Objections and comments on the Campus East (Bellway scheme) application from 'Keep the G in WGC'

FIG 53 - CYCLE PARKING STRATEGY

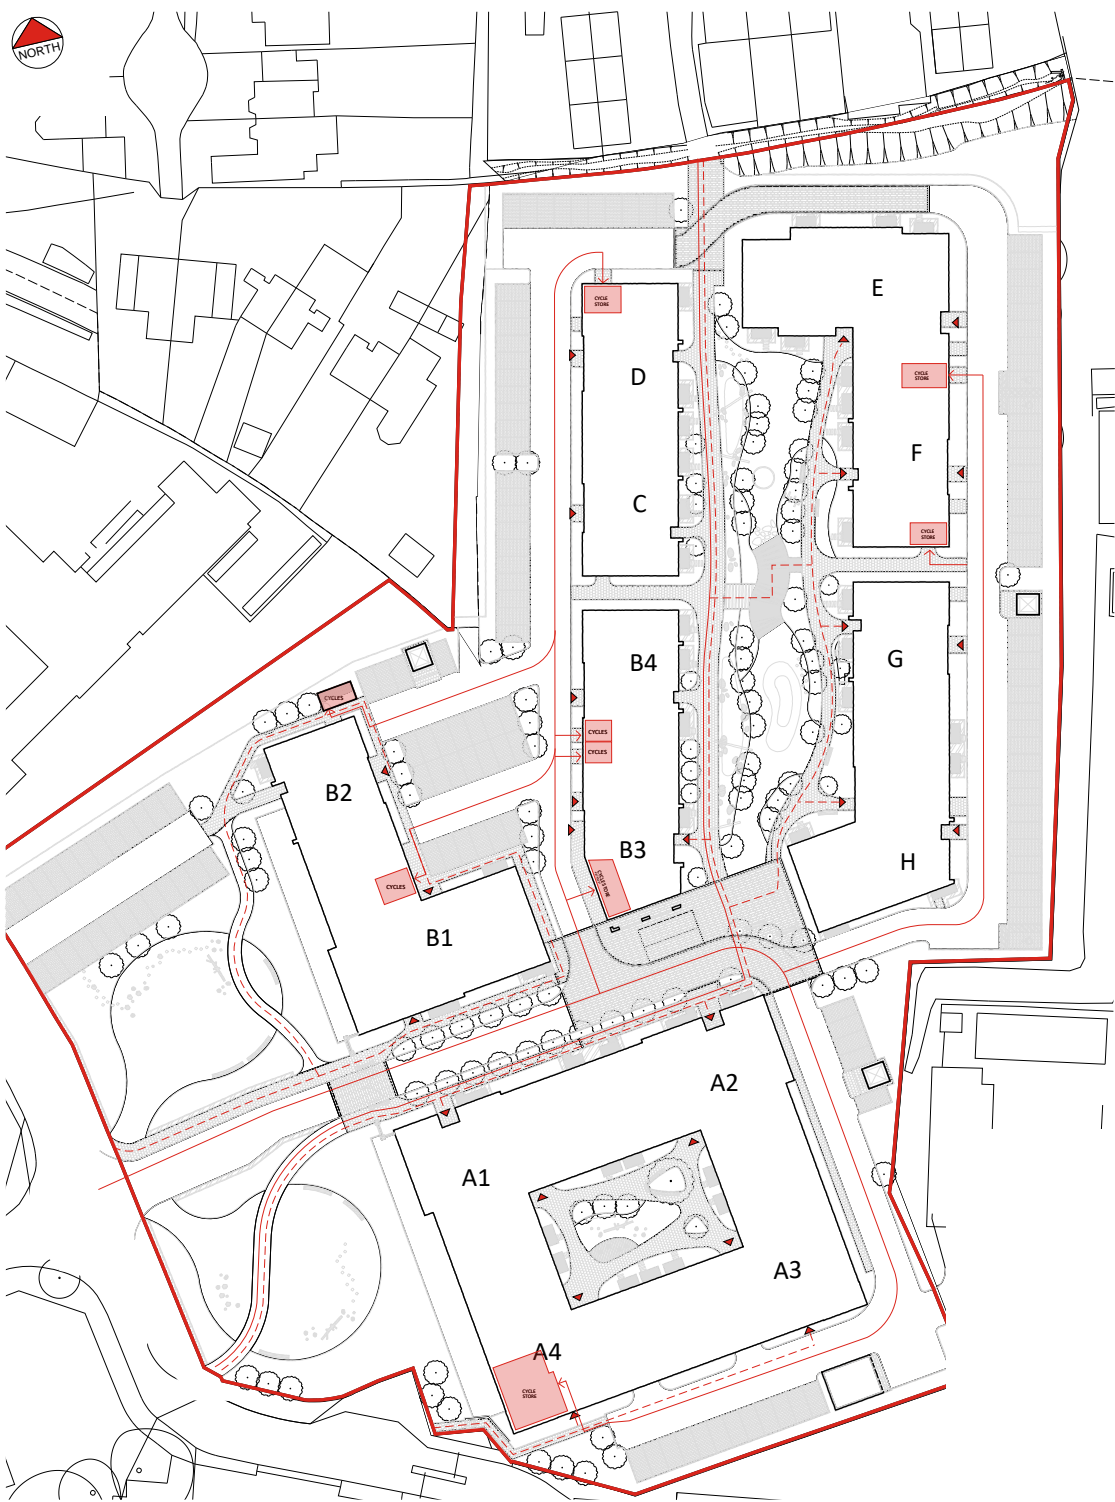
No attempt is being made to provide a cycle route extension from the eastern end of the Ayot Greenway to for example Bridge Road, to link with the new cycle lanes across Hunters Bridge. This should be addressed.
